**MONUMENT FIRE DISTRICT**  
16055 Old Forest Point, Suite #102  
Monument, CO 80132  
(719) 484-0911  
www.monumentfire.org  
*Proudly serving the Tri-Lakes Region*

February 21, 2024

Ref: Society of Classical Christian Education (SocCe) Site Dev plan

PROJECT NO. _____ SHEET
 DATE: 4/3/24 **C1**

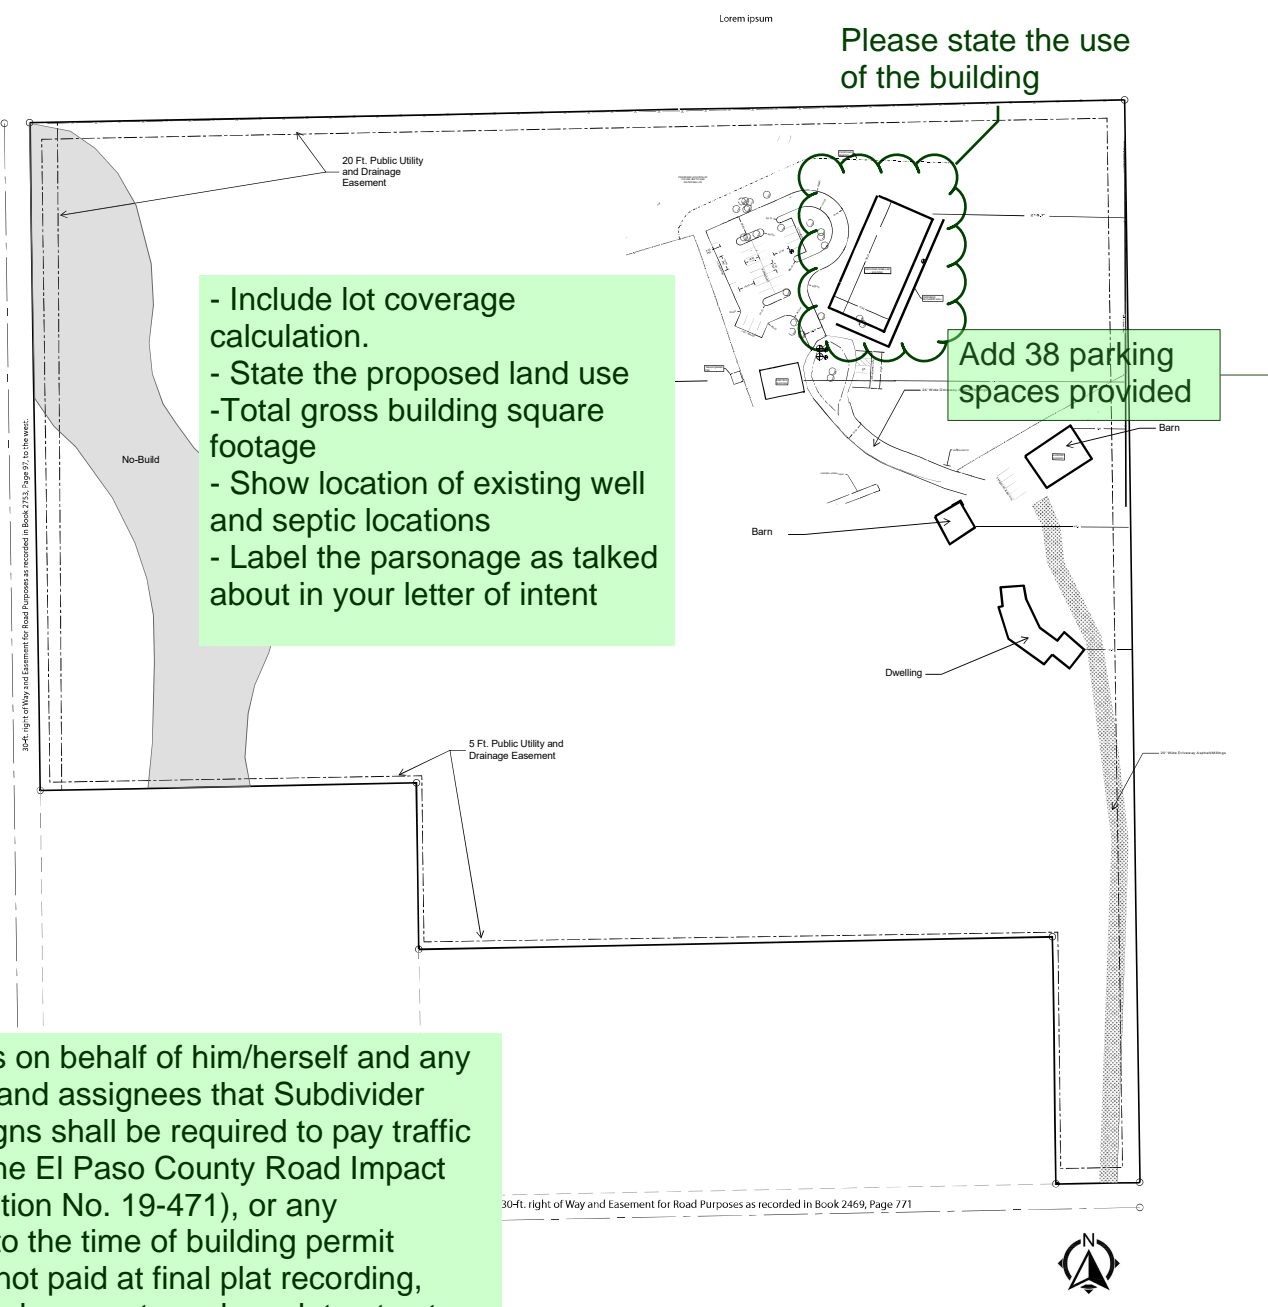
- Site access and address for the site. This section of Walker Road has been a problematic issue, and now that commercial property is being developed, it needs to be addressed.
  - FD access for apparatus compatible with a commercial structure
- Water Supply to the site for fire suppression activities
- Compliance with the 2015 IFC as adopted by the FD for educational and retreat activities, as noted in the cover letter
- All building plans will need to be reviewed by CSFD Construction Services for compliance with the adopted 2015 IFC.

This site plan must address required FD access and water supply; however, the more significant issues will be the water supply for fire suppression systems in educational and residential facilities as described in the letter of intent.
